Tuesday, April 19, 2022

Matt Grush, P.E., Senior Traffic Engineer
Transportation Development Section
City of Albuquerque Planning Department
600 Second St. NW
Albuquerque, New Mexico 87102

Re: Oxbow Development / Coors Pavilion (St. Josephs Dr. / Coors Blvd.)

NAME: N:\Projects\W0007 Skansgard\W0007.0004 Skansgard Oxbow Center\3_CAD\W0007.4 Road Section Exhibits 021722.dwg PLOT DATE: Apr 15, 2022 9:05am

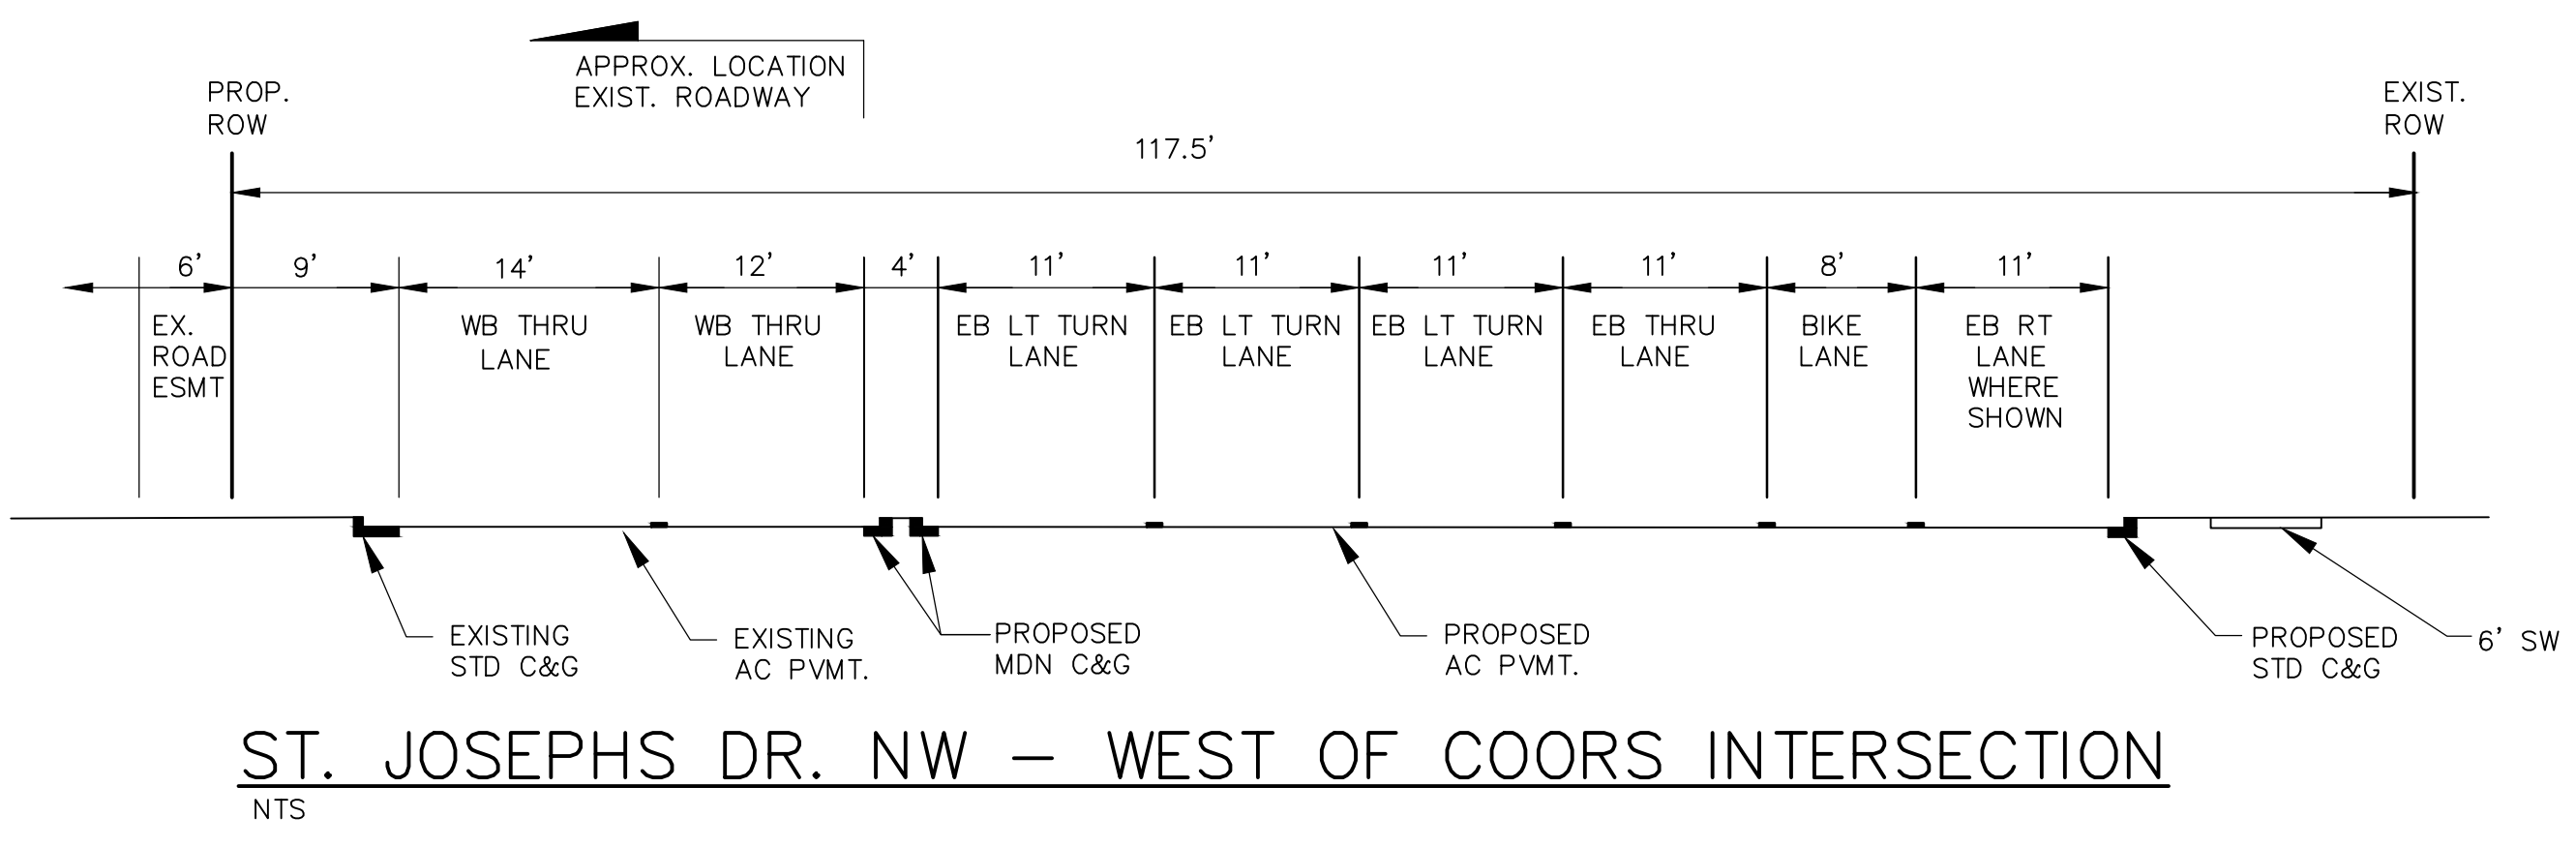
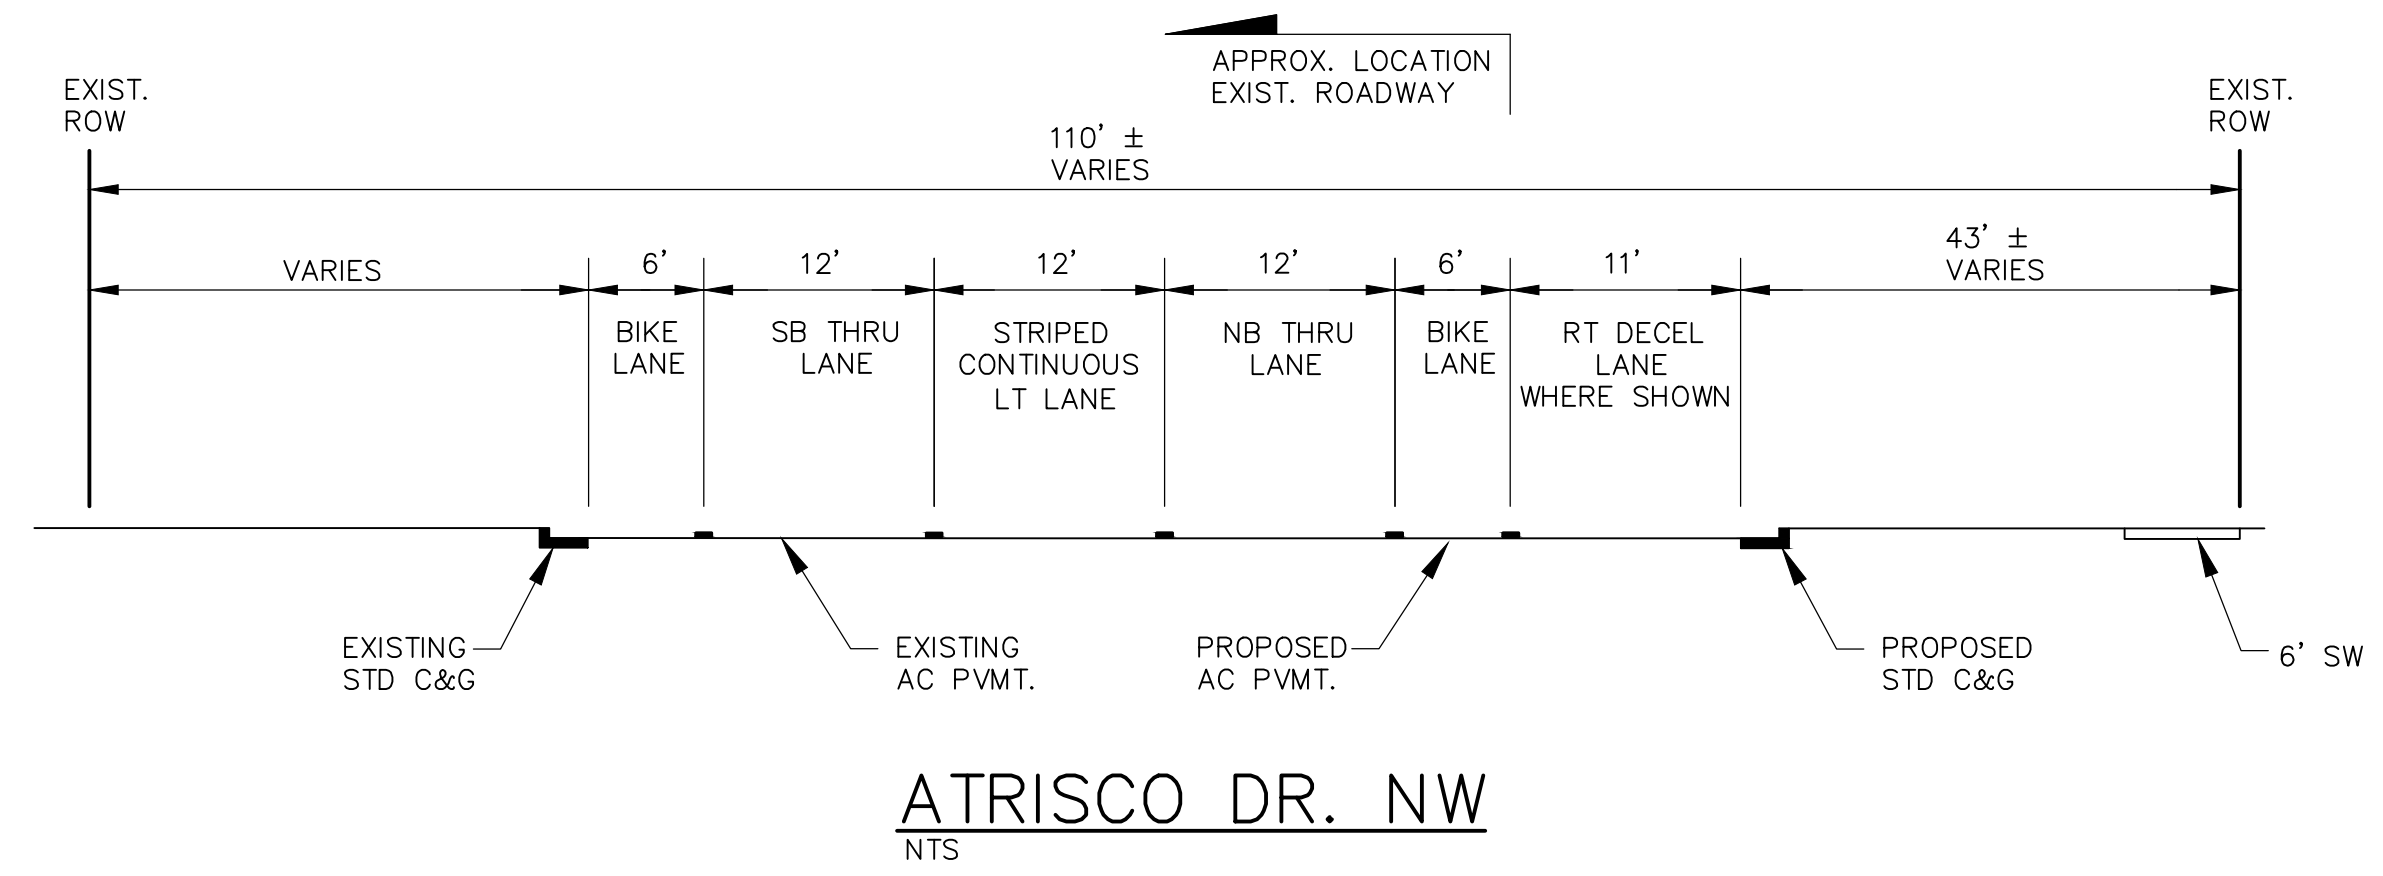
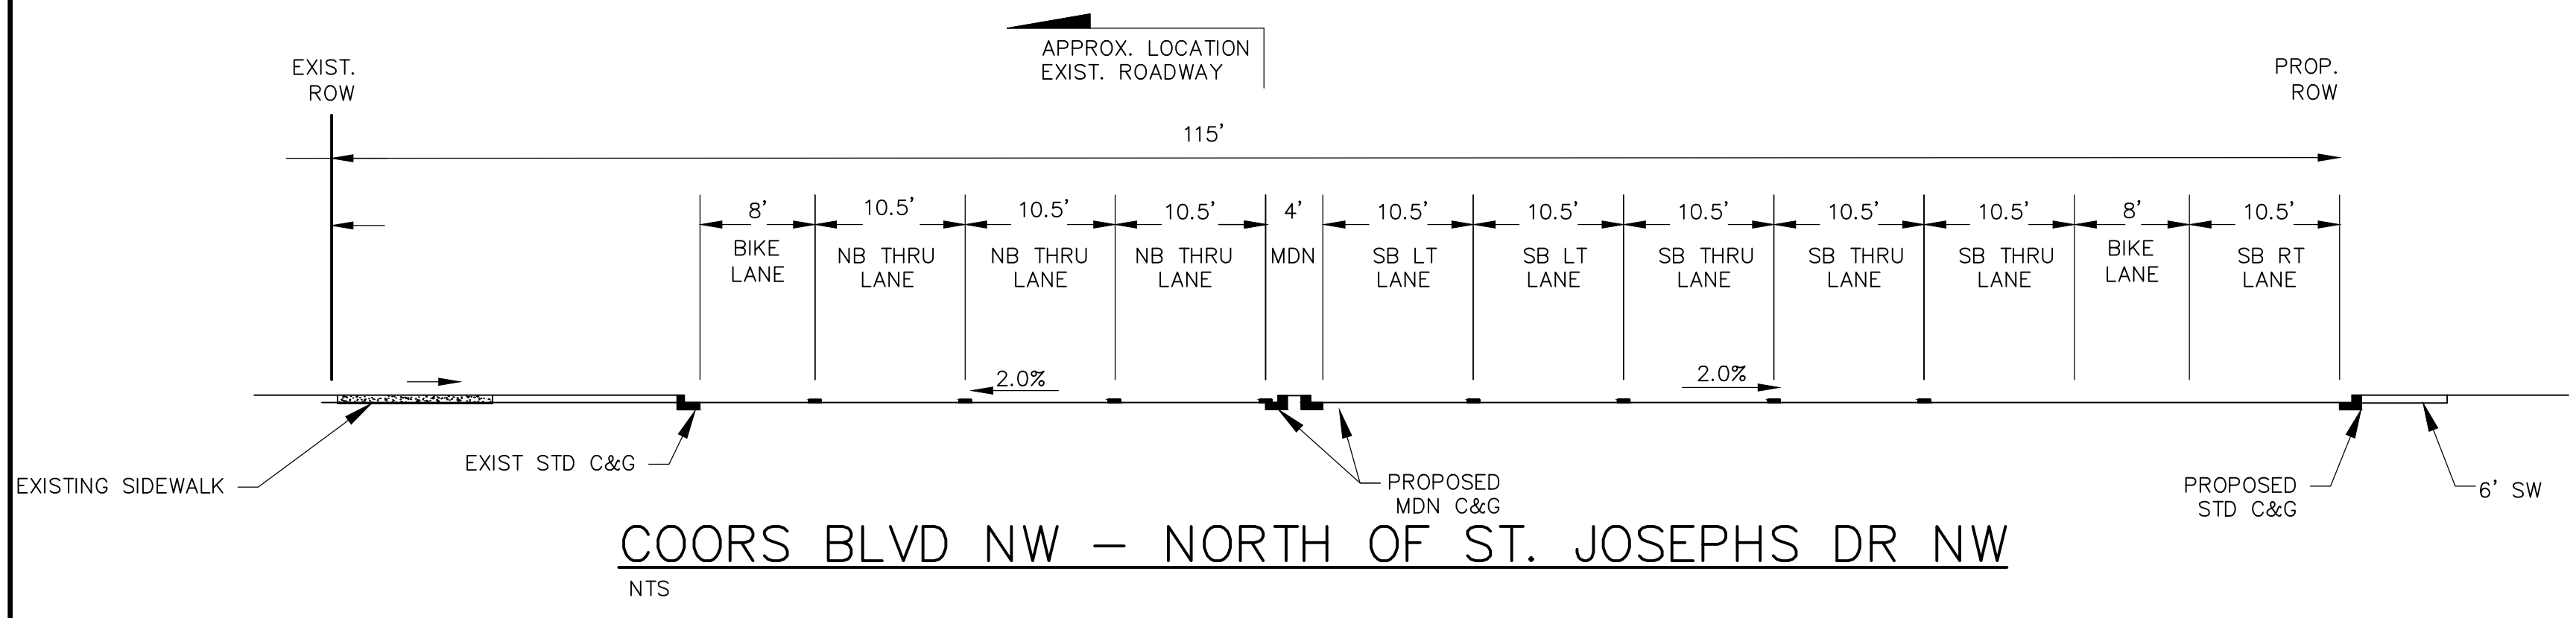
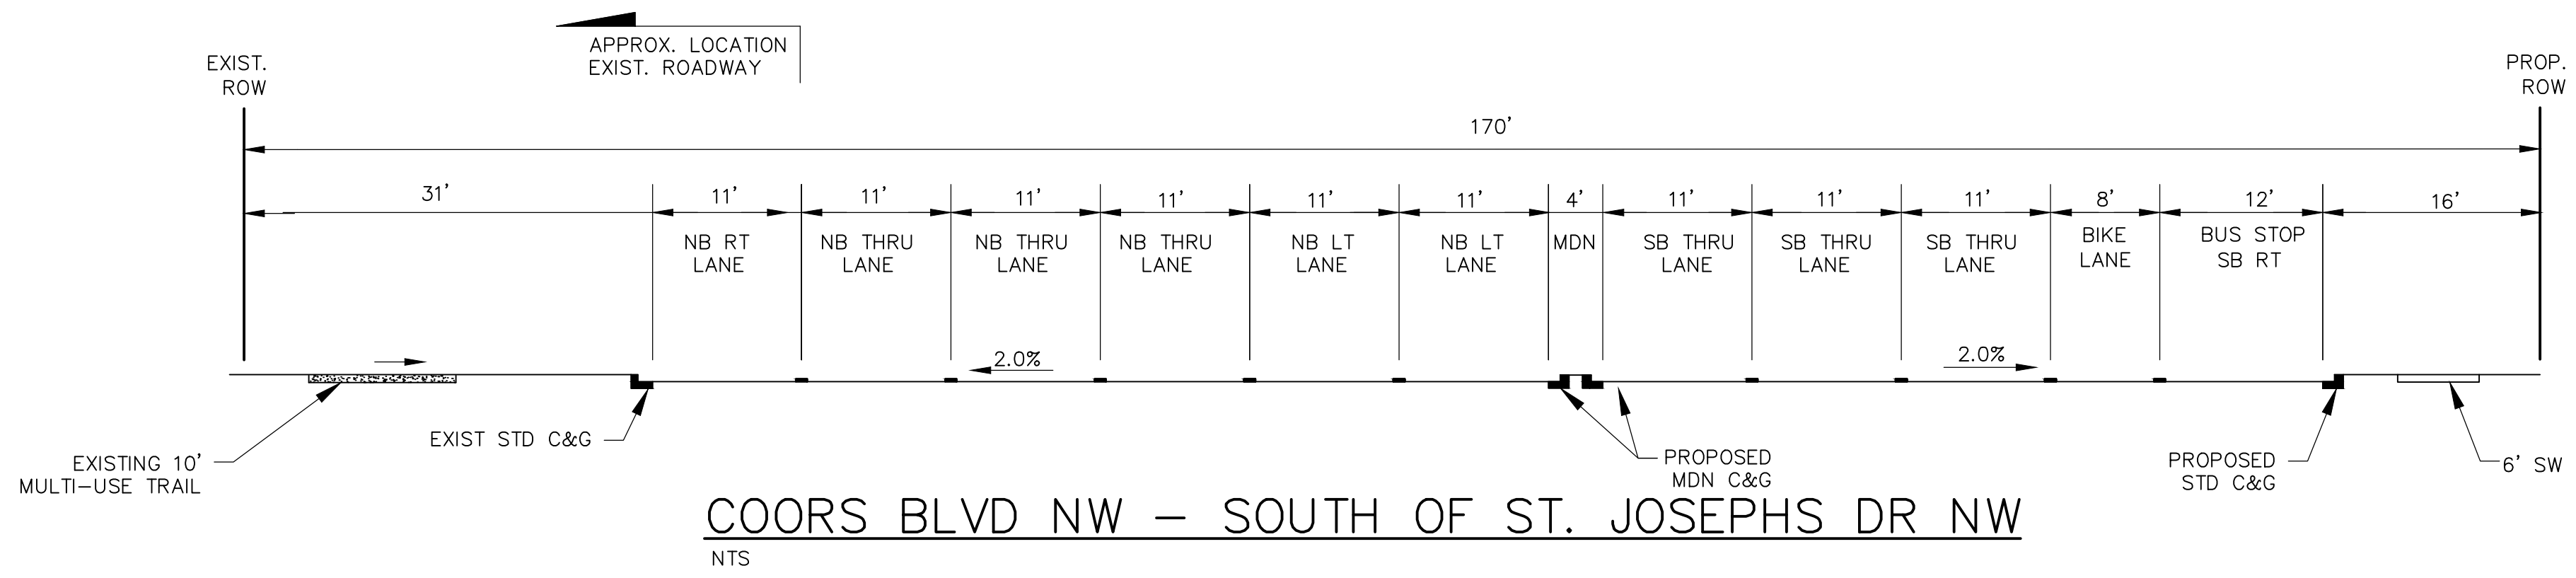
Comment: Add eastbound bicycle lane with buffer to the cross-section.

Comment: Provide a conceptual footprint of the main entrance to show that it will fit in the existing ROW. Add the eastbound bicycle lane with buffer.

Response: We acknowledge that the developer will be required to construct St. Josephs Dr. from Atrisco Dr. to Coors Blvd. to meet all of the City of Albuquerque's Design Standards in the Development Process Manual including bicycle lanes.

Response: The attached graphical conceptual roadway plan demonstrates that the main entrance will fit in existing ROW and an eastbound bicycle lane is shown.

| SHEET NO. C-100 | |

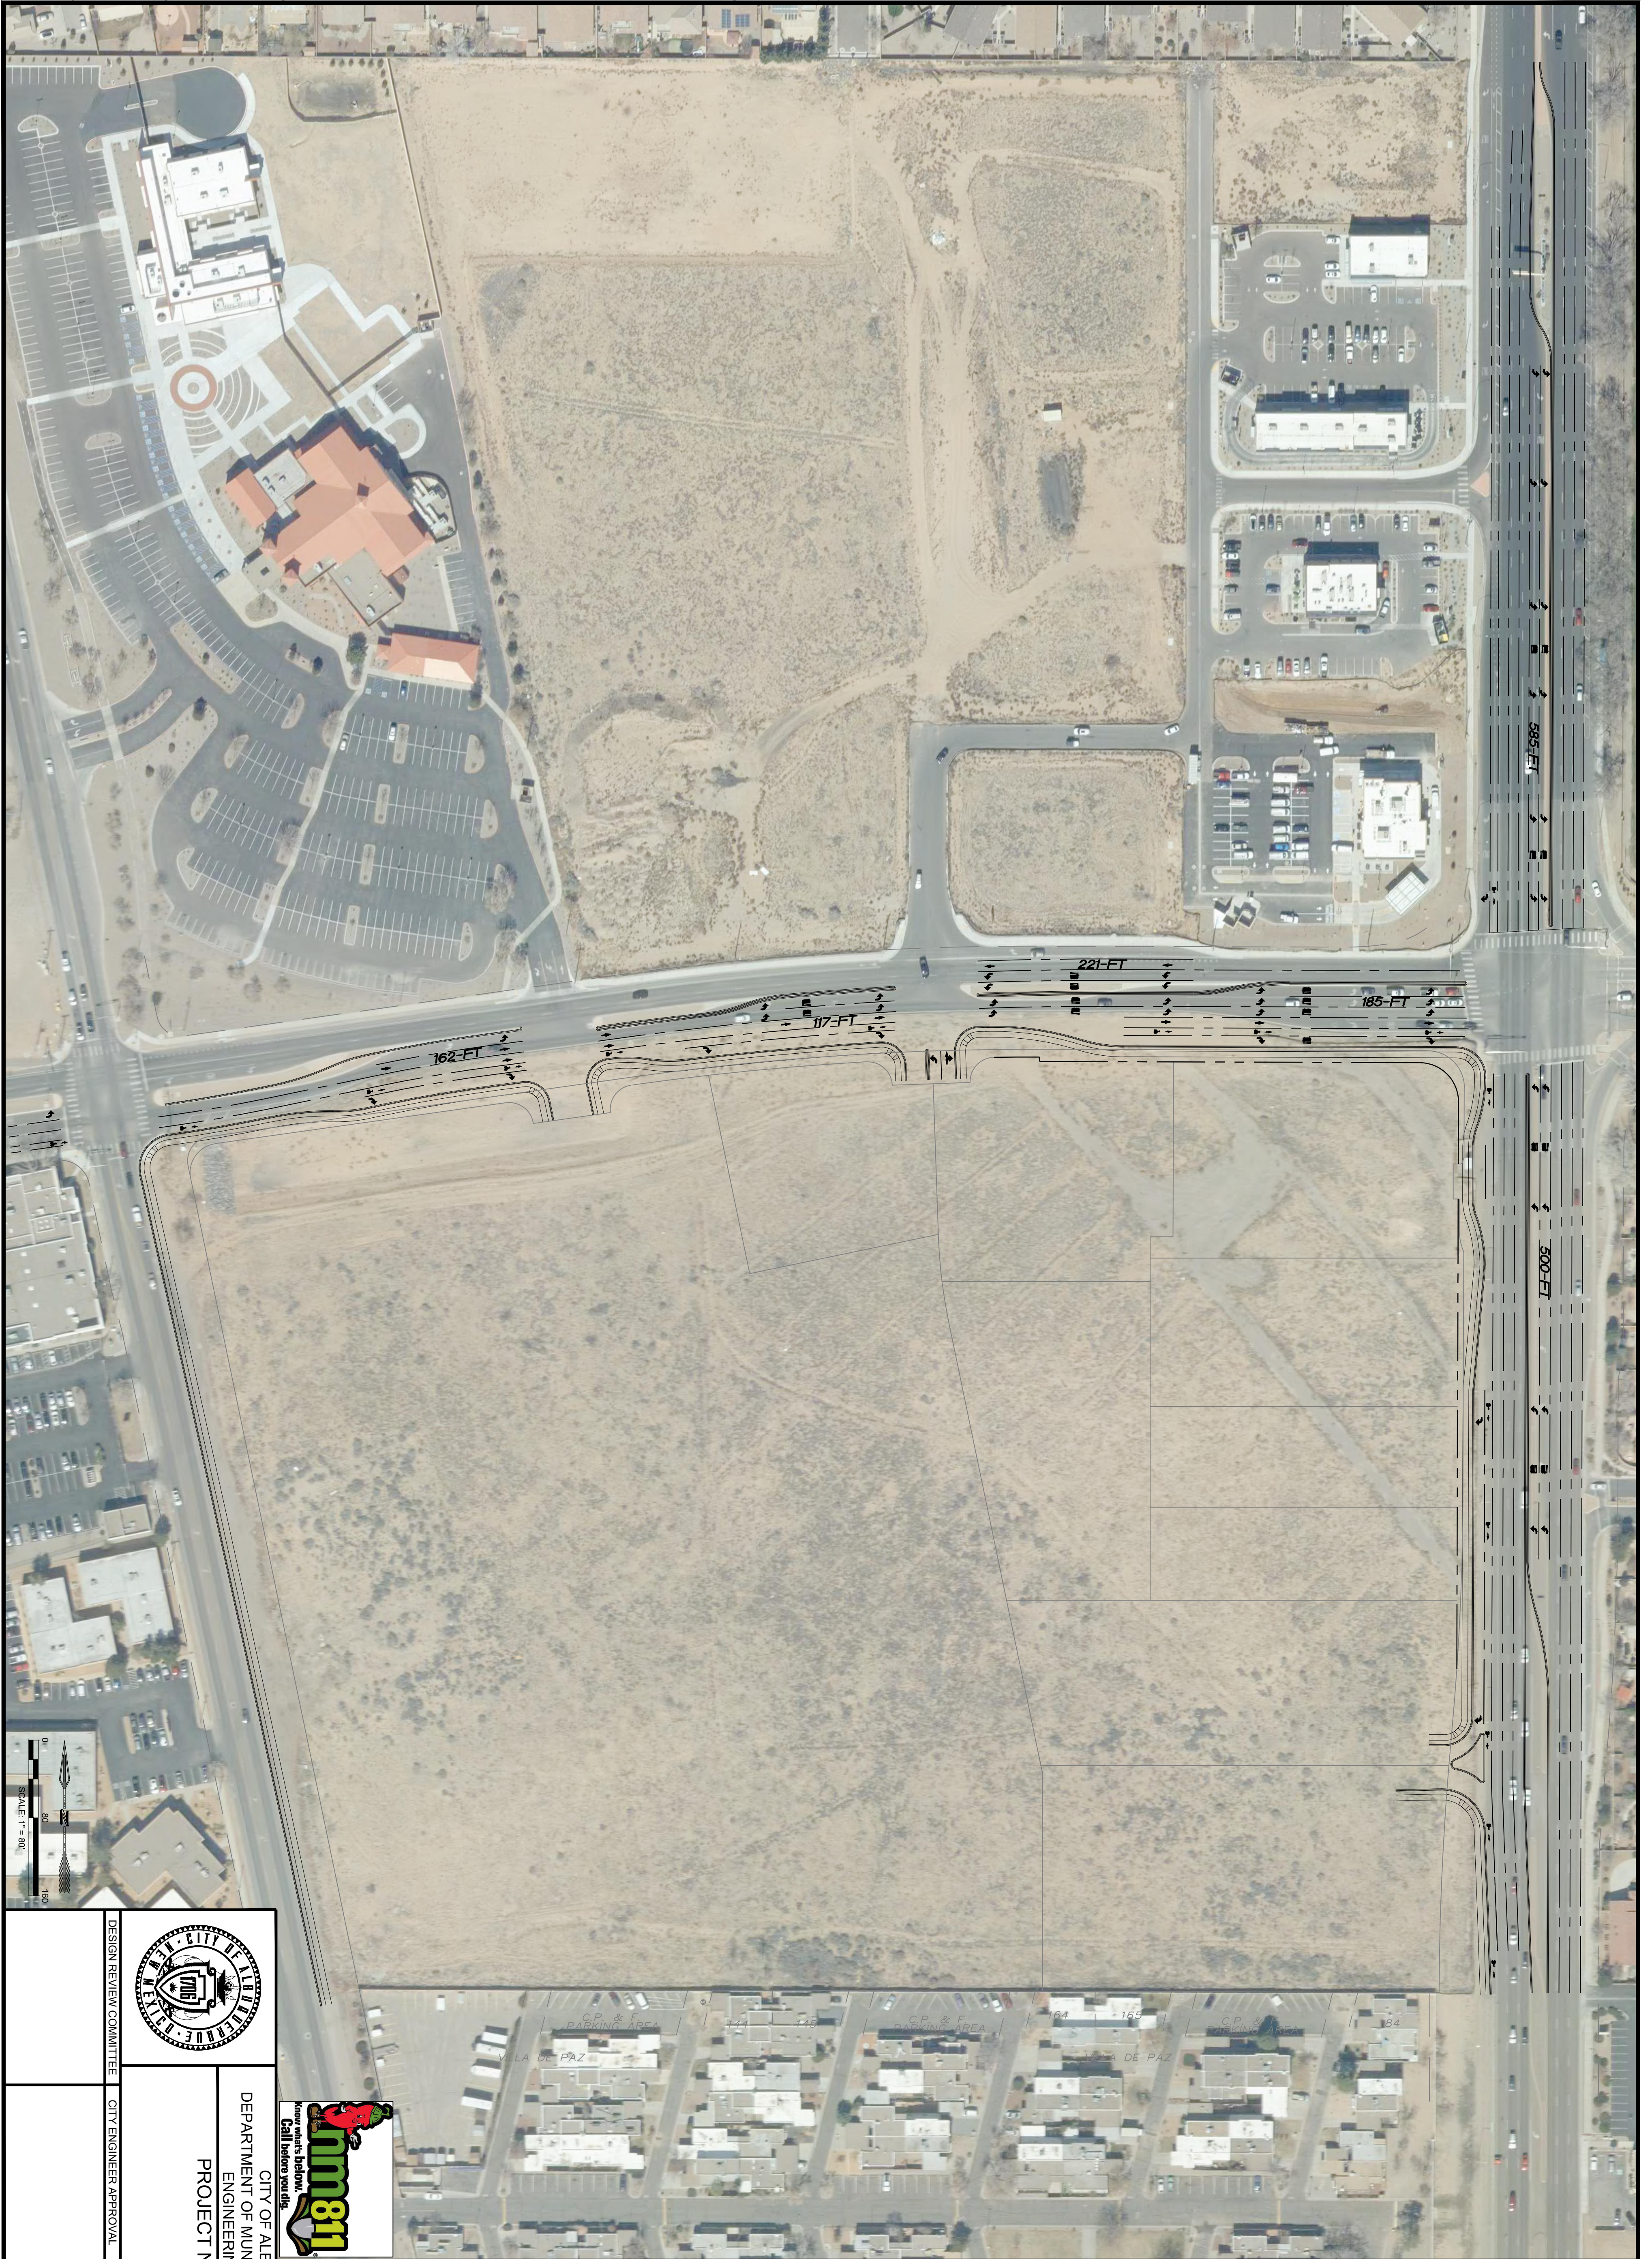
Comment: Provide a conceptual footprint to determine the available ROW and what unforeseen infrastructure impacts are anticipated i.e. traffic signal modifications / relocation ...

Response: Attached is a graphic conceptual roadway plan developed by Sheldon Greer, P.E. at RESPEC Engineering that demonstrated sufficient ROW available for the recommendations in the TIS.
